City of Portland, Maine - Building or Use Permit Application
 389 Congress Street, 04101 Tel: (207) 874-8703, Fax: (207) 874-8716

Permit No: 05-1565	Issue Date:	CBL: 016 H002001
------------------------------	--------------------	----------------------------

Past Use: 2 unit residential	Proposed Use: 3 unit residential/ Change of Use Garage to 3rd living unit/ Bathroom, new stairs, interior renovations of garage	Permit Fee: \$114.00	Cost of Work: \$2,000.00	CEO District: 1
Proposed Project Description: Change of Use Garage to 3rd living unit/ Bathroom, new stairs, interior renovations of garage		FIRE DEPT: <input type="checkbox"/> Approved <input type="checkbox"/> Denied	INSPECTION: Use Group: Type	
		Signature:	Signature:	
PEDESTRIAN ACTIVITIES DISTRICT (P.A.D.)				
Action: <input type="checkbox"/> Approved <input type="checkbox"/> Approved w/Condition <input type="checkbox"/> Denied				
		Signature:	Date:

PLAN FOR 48 MONUMENT STREET, PORTLAND, ME
 GARDEN CONVERSION TO EFFICIENCY APARTMENT
 BY: JOSEPH REYNOLDS 10/05

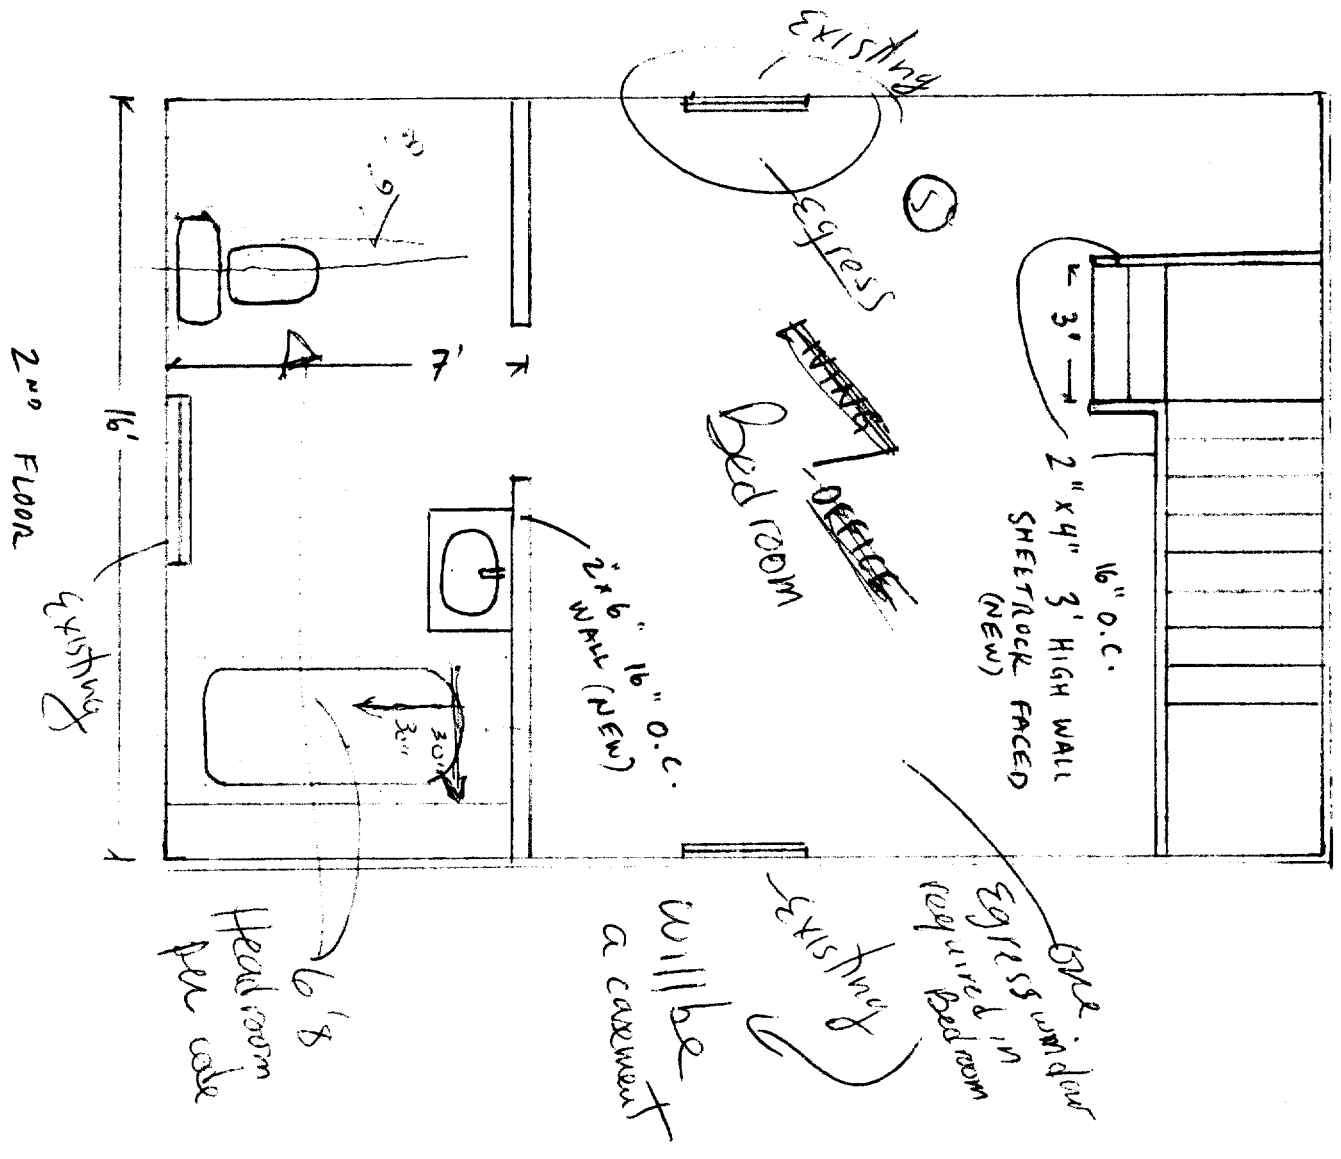
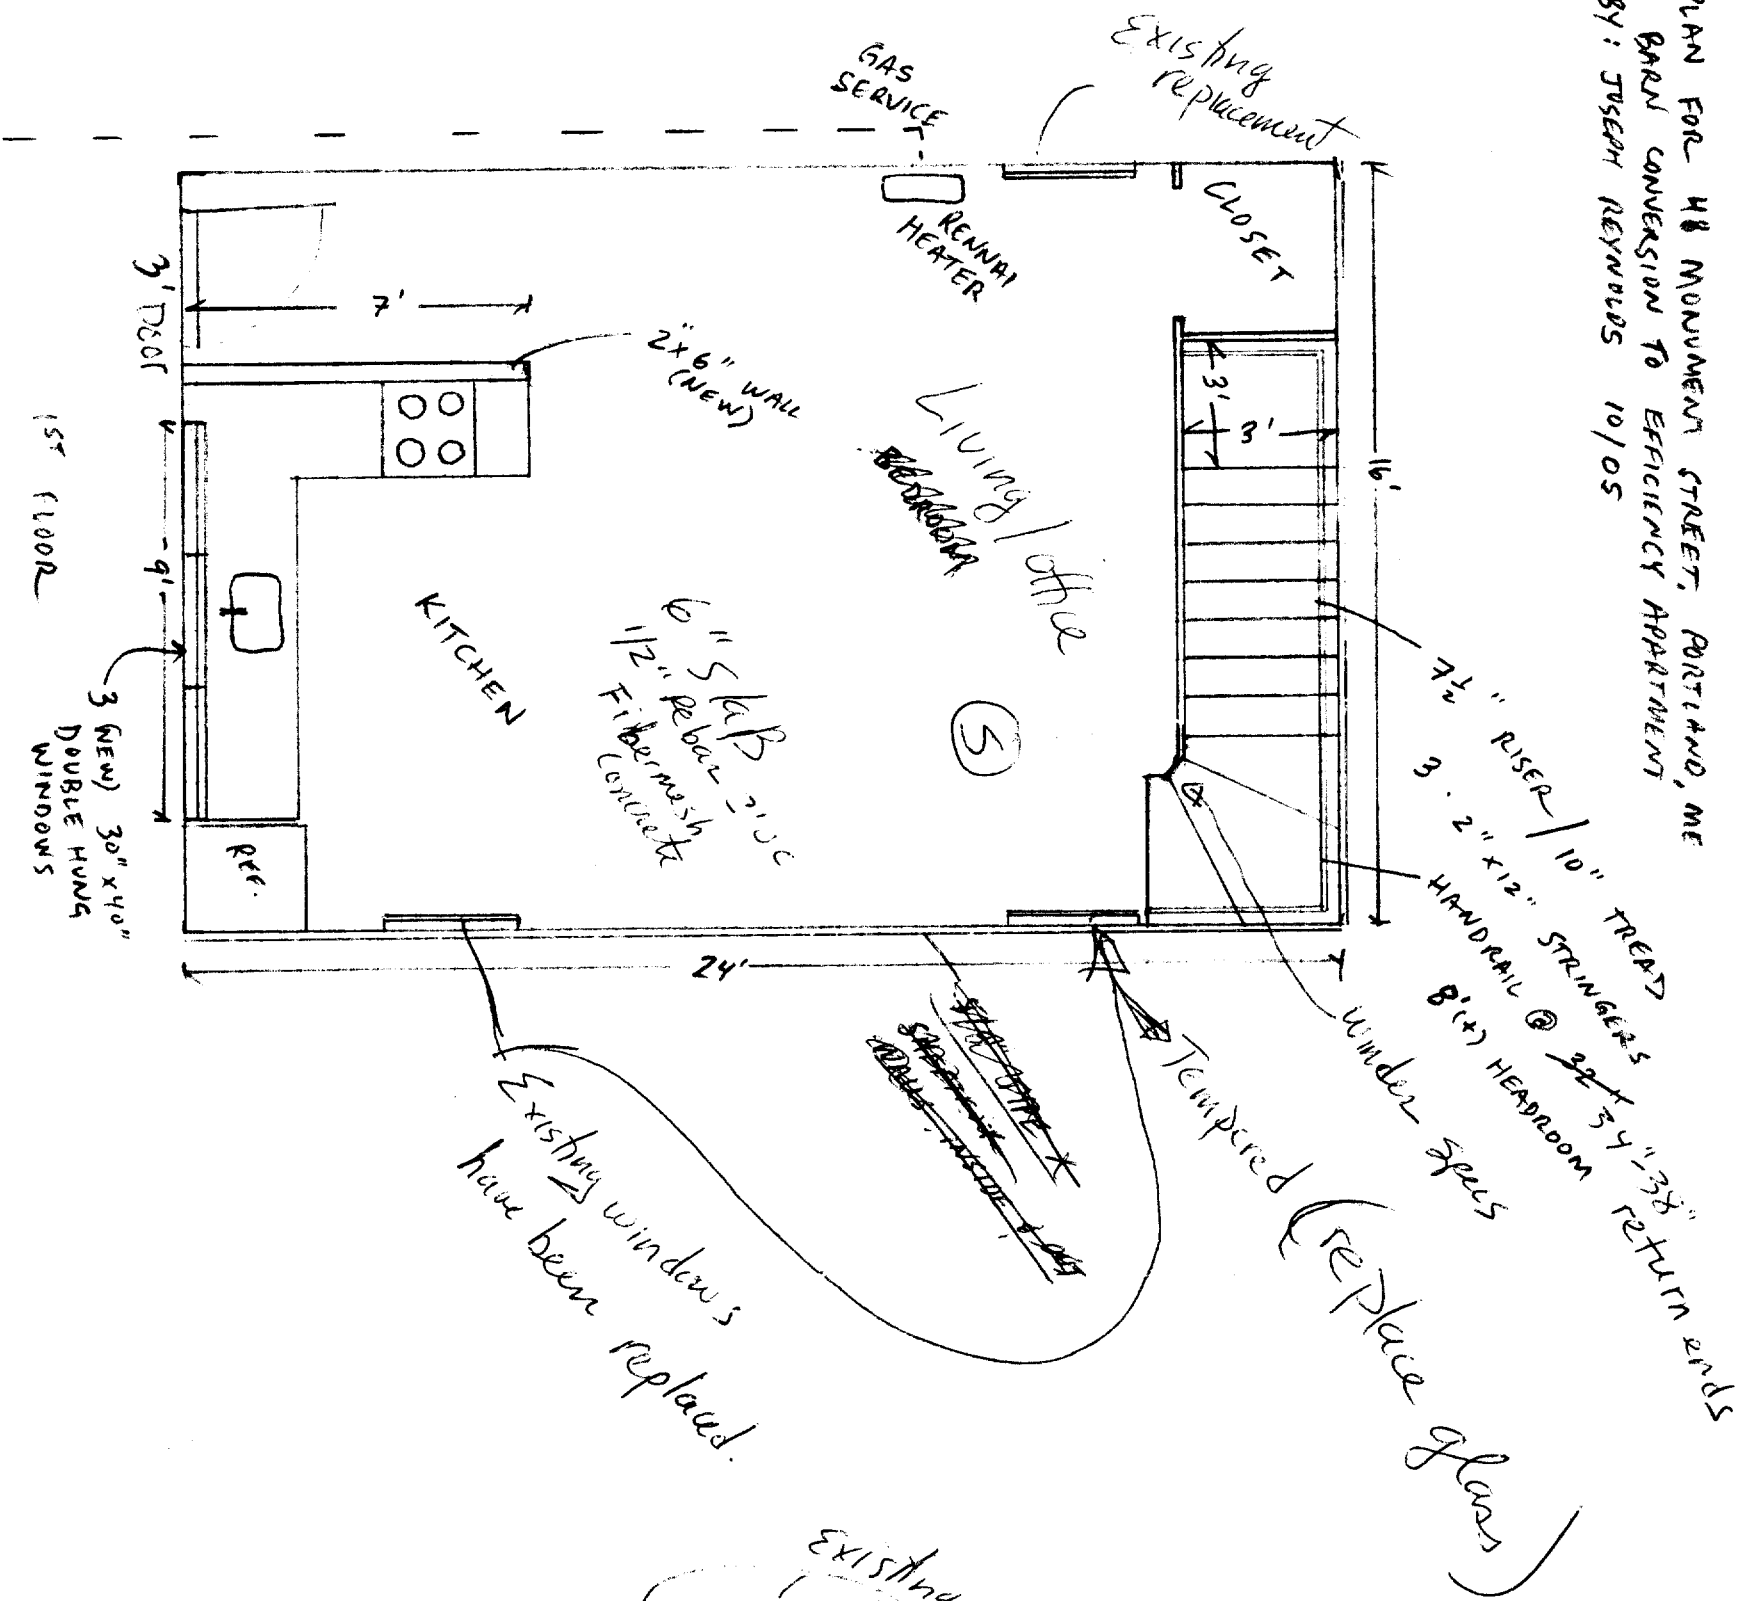
11/15/2005-jmb: Spoke w/Joe R. About review items, he checked floor joists to be full 2x8 @ 16" o.c. W/midspan bridging. Also the distance at the close side yard is 16' to the retaining wall/parking area. Need to discuss code issues with MJN.

11/22/2005-jmb: Discussed codes w/MJN, no requirement for rated walls for existing structure. Must provide one egress window in the 2nd floor bedroom, and tempered glass in the window at the bottom of the stair. Spoke w/Joe R., he will confirm windows tomorrow.

PLOT PLAN FOR PROPERTY AND EXISTING STRUCTURES
 OF JOSEPH REYNOLDS
48 MONUMENT STREET
PORTLAND, MAINE

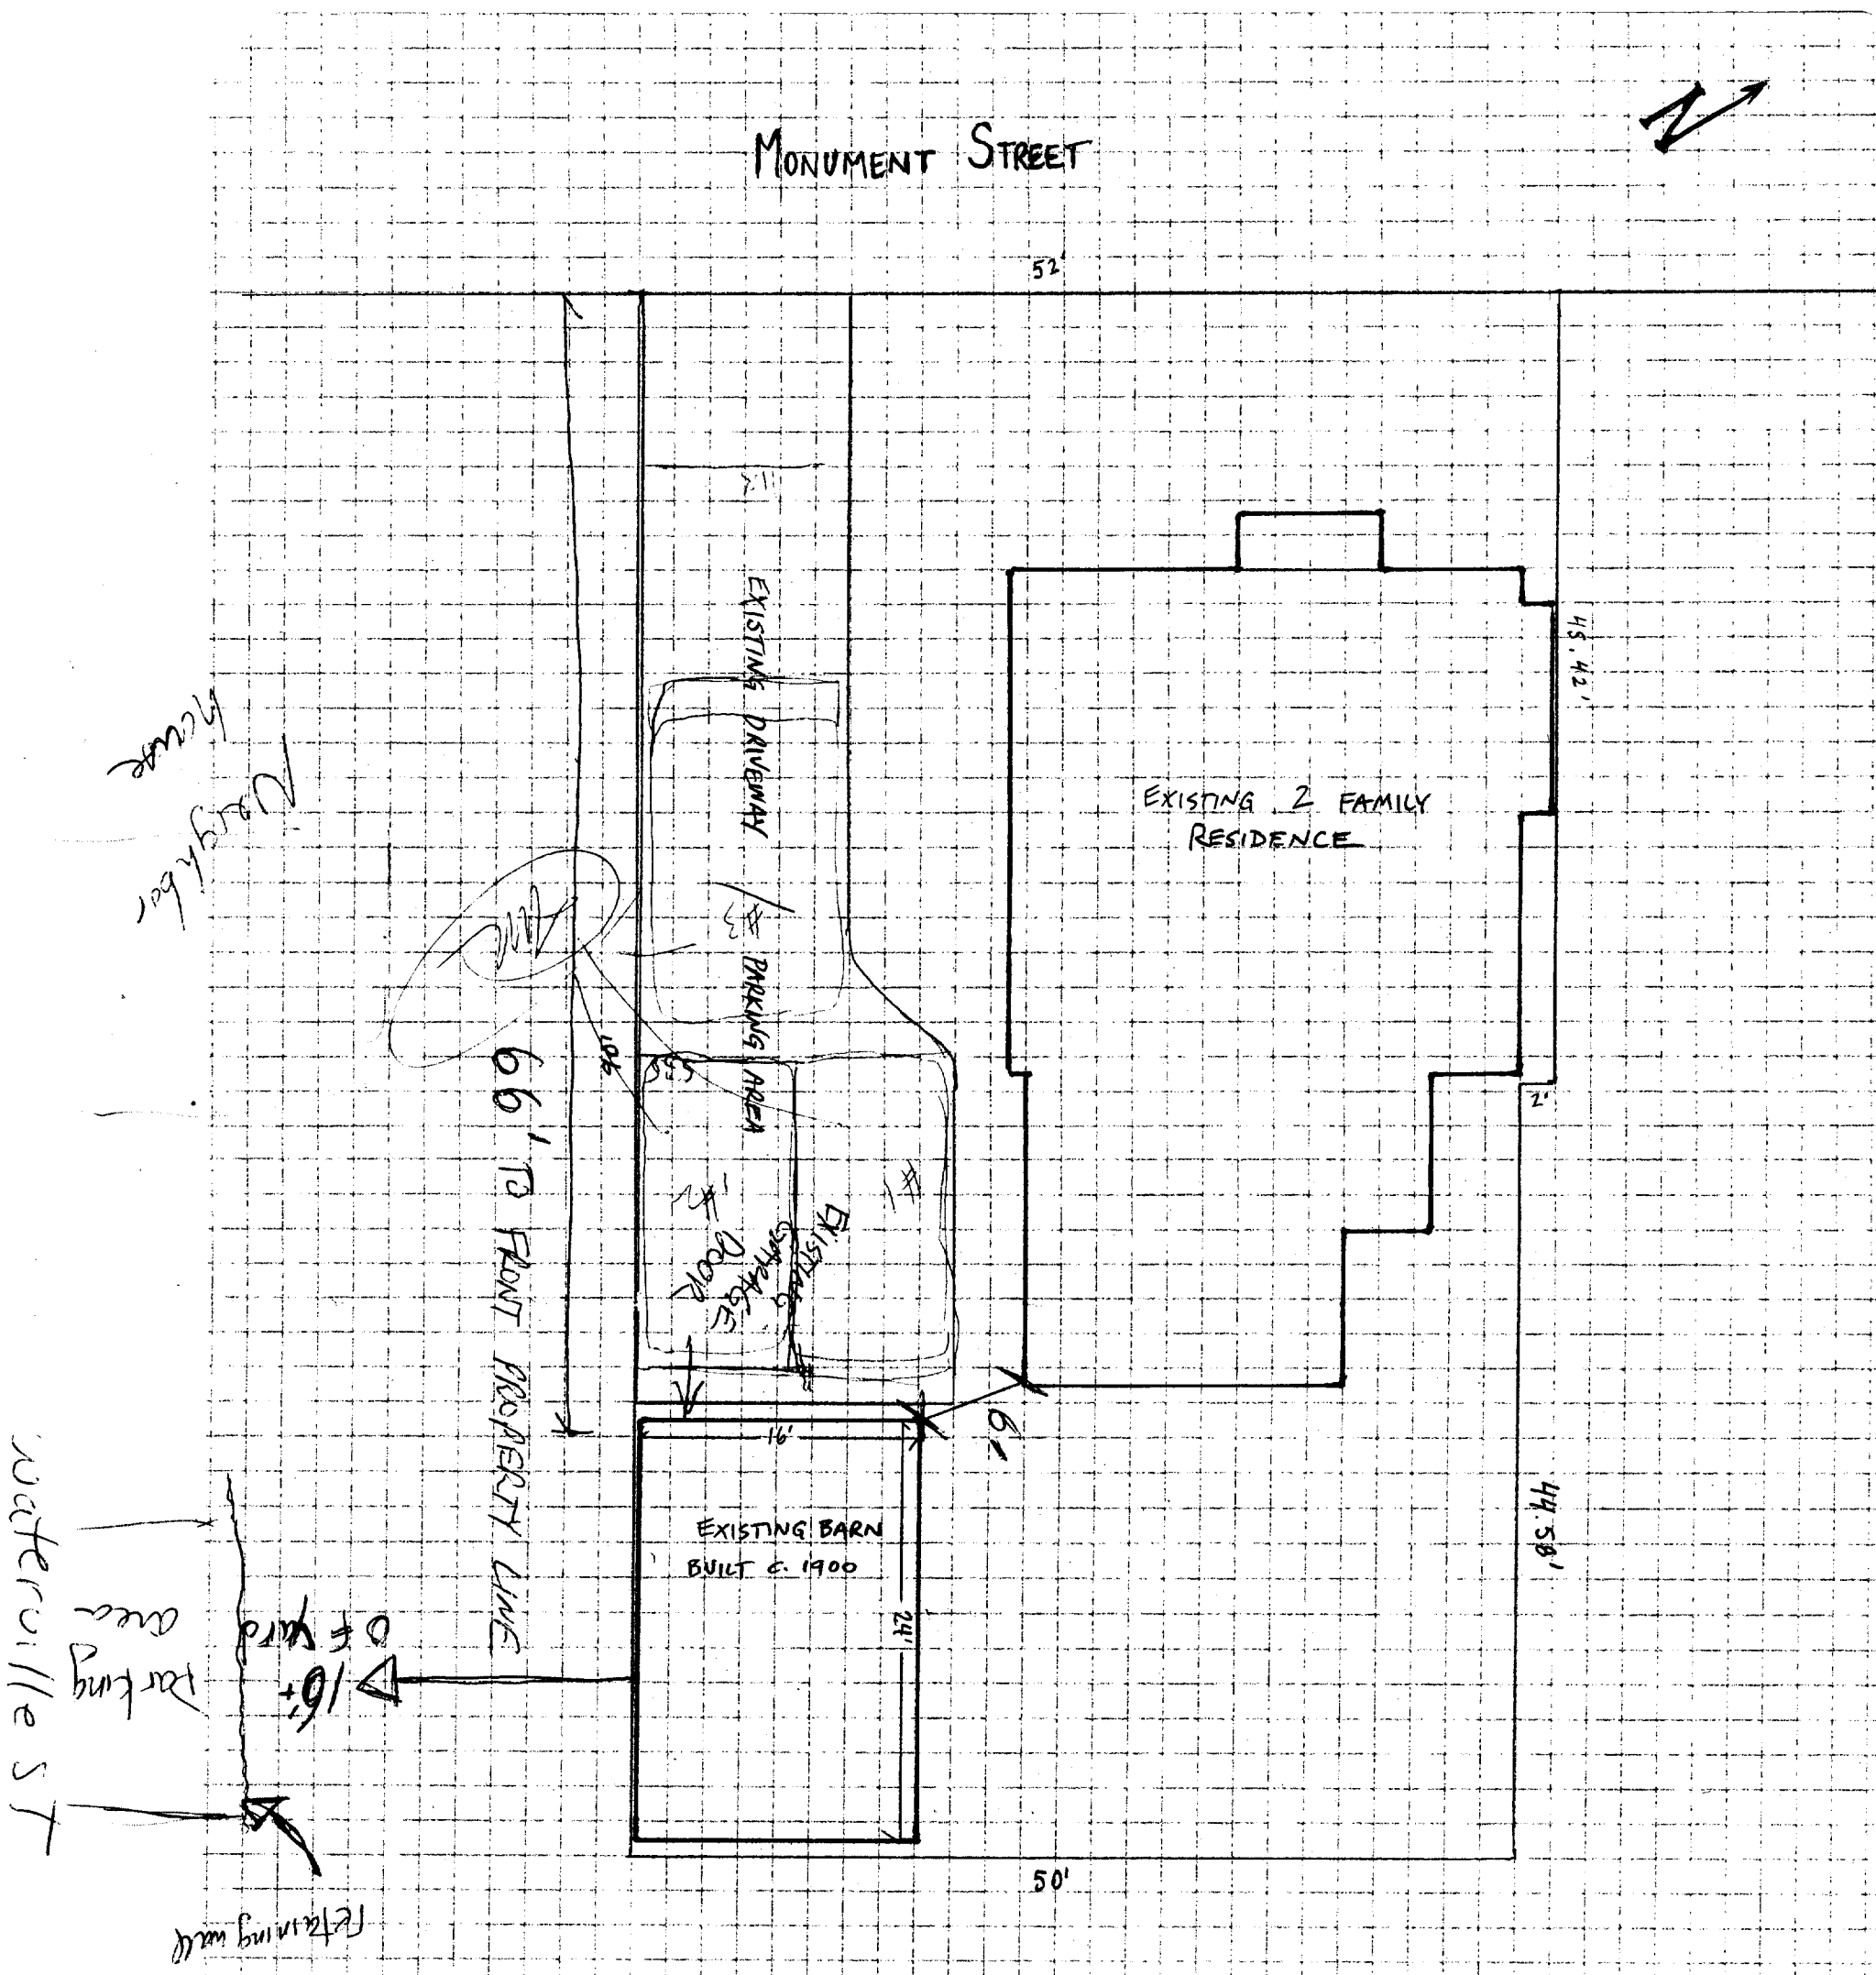
Note: 11/07/05 Left message w/joseph. Needs to show 3 parking spaces on plot plan . **Ok to Issue:**
